Our Ref: PAA/171/17/

8th March 2018

Pre-Application Advice

Proposed erection of 27No. Dwellings.
Boweries Barnham Road Eastergate Chichester

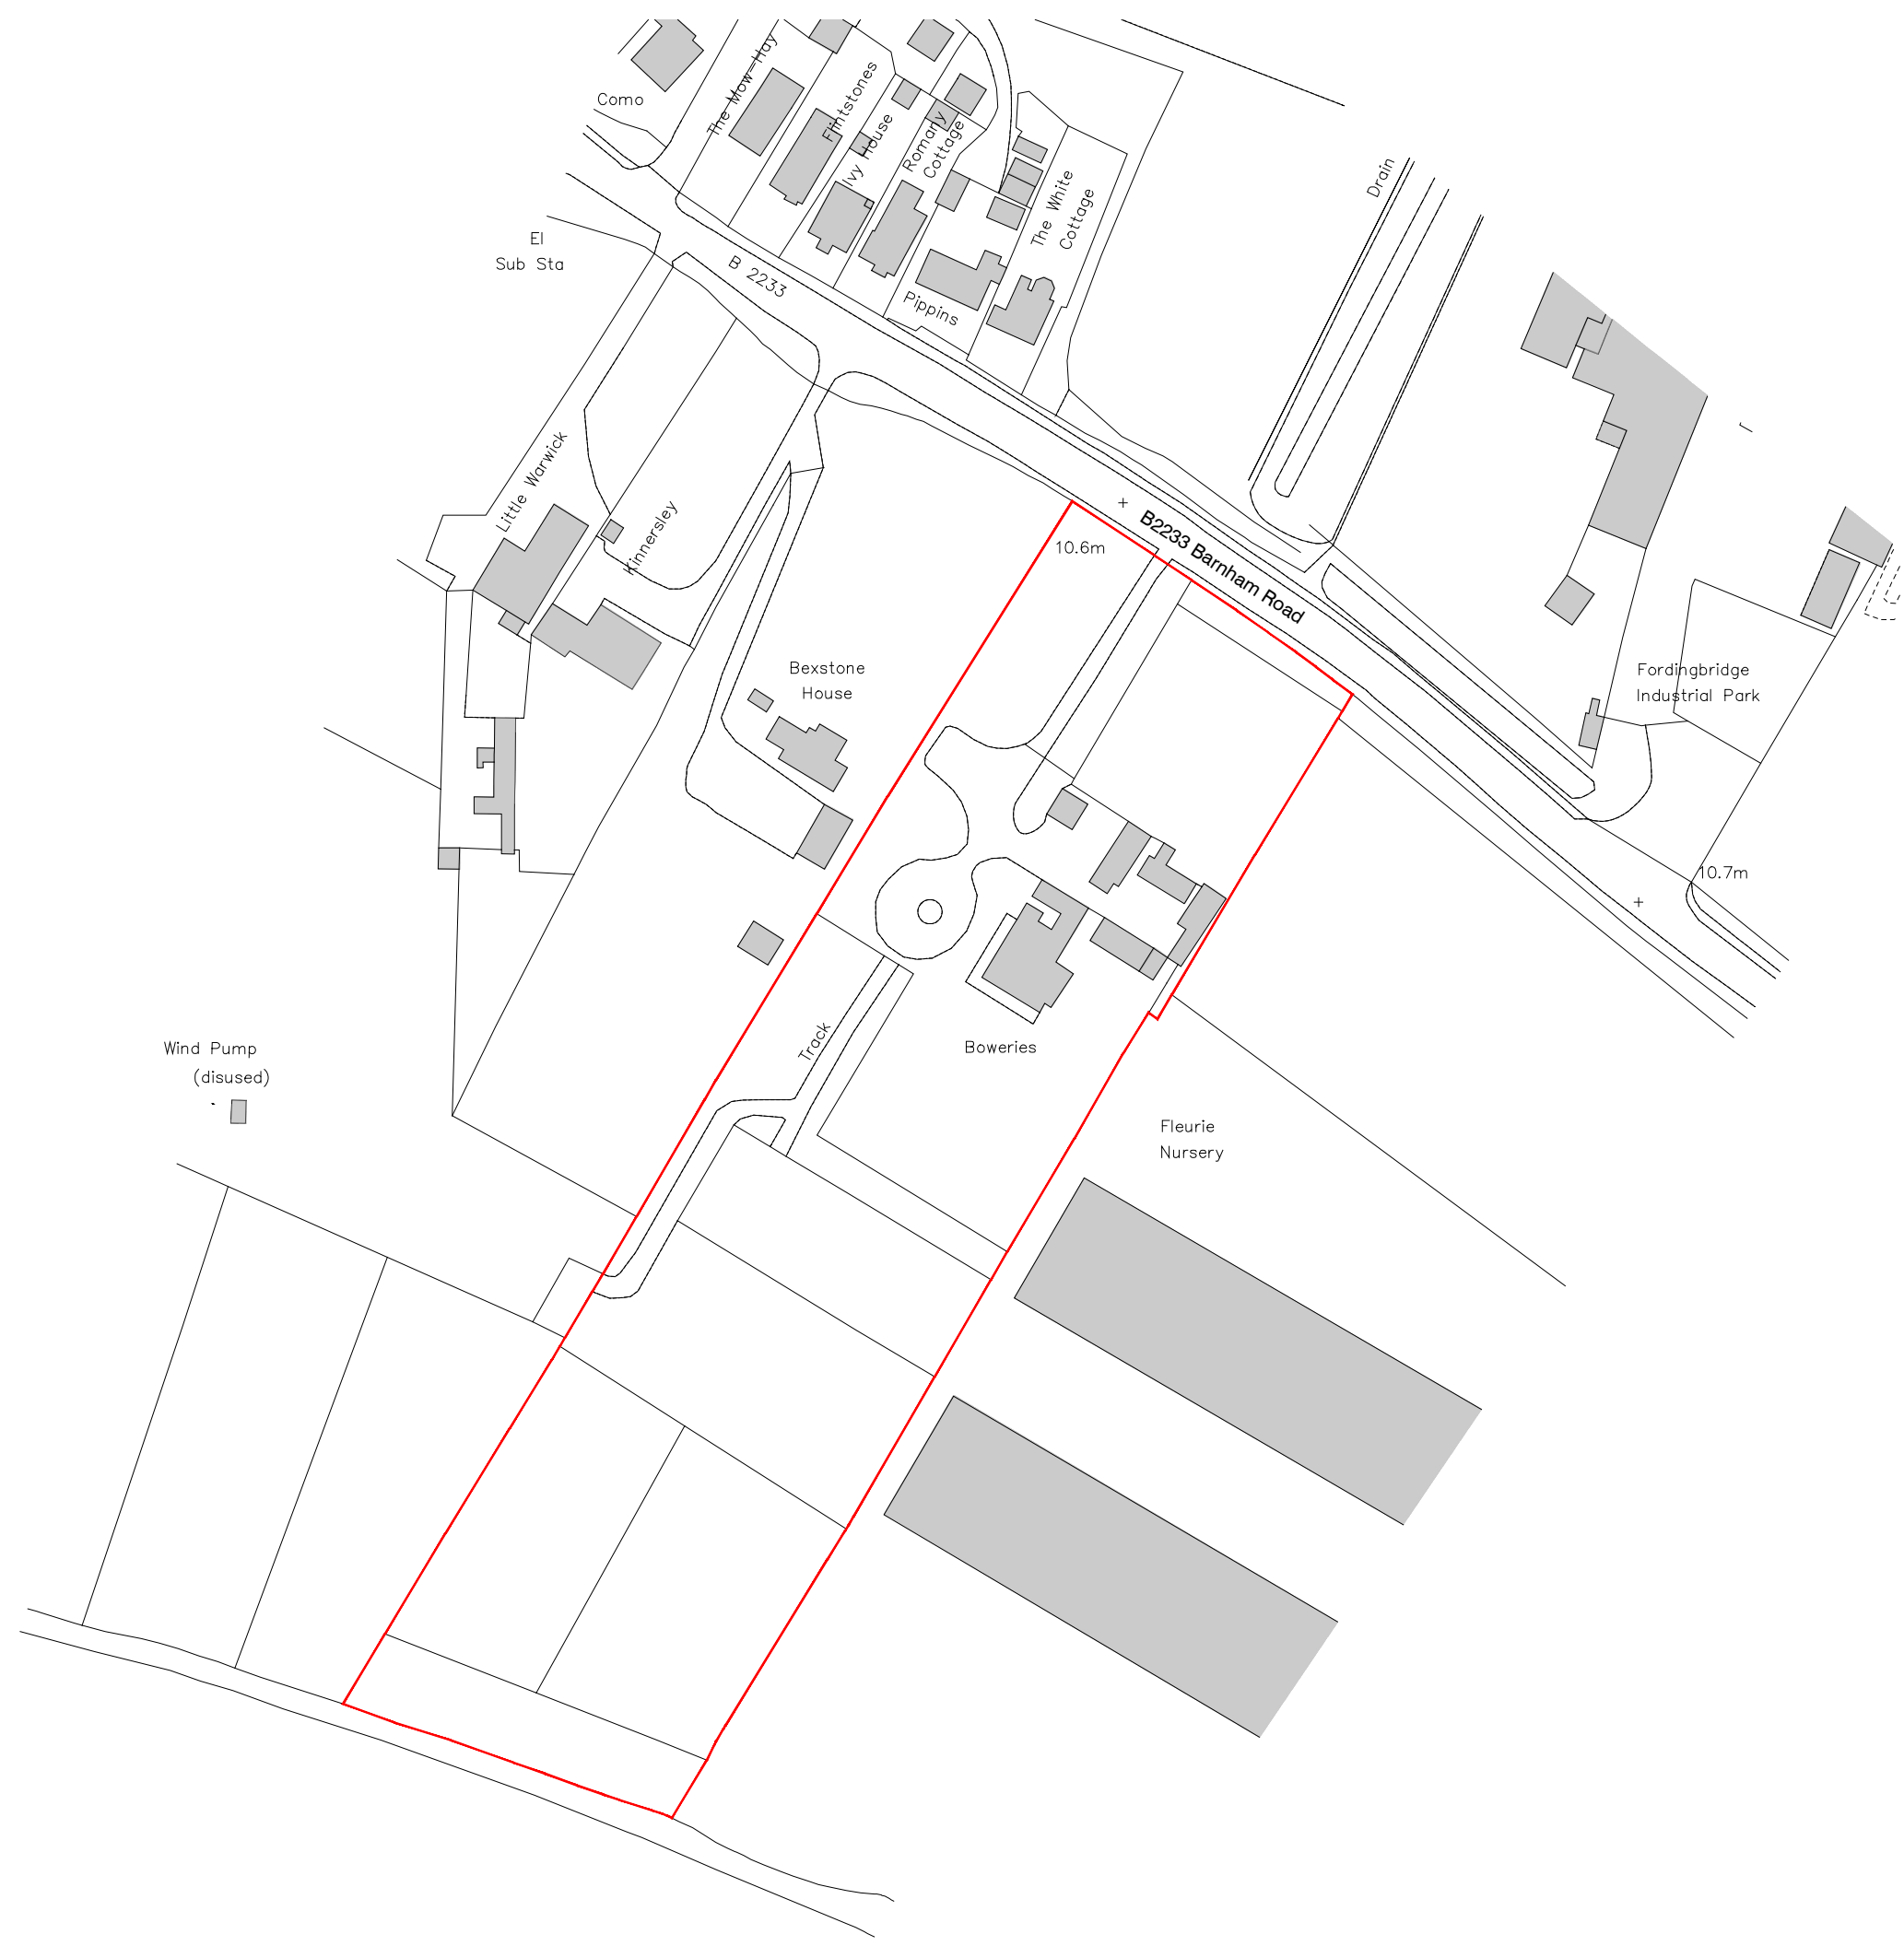
The site is long and narrow which leads to a less than ideal site layout, with properties facing the side fences of other properties and garden fences facing onto the main street. The LEAP is an awkward shaped space to the side of the road. These issues would be overcome and a more acceptable place developed if the site is incorporated into the BEW masterplanning process. This would allow for the site to be designed with adjacent parcels of land, and open up opportunities for designing a successful scheme, rather than a linear cul-de-sac. As set out above, a detailed Masterplan needs to be developed for the site in order to set clear parameters for the design of the site in the context of the allocation.

Policy HDQ8 of the BENP requires good quality private amenity space to be provided. Based on the current layout, I would have concerns about the ability to achieve sufficient outdoor private amenity space for some of the plots shown.

We would require confirmation of the areas of public open space being proposed with this development, as a minimum proportionate to the proposed dwellings. As a stand-alone development this would appear to be deficient in open space offer and without masterplan connectivity to adjacent land difficult to assess (stand alone requirement would be for this proposal to provide .20Ha POS, LEAP, LAP and MUGA contribution).
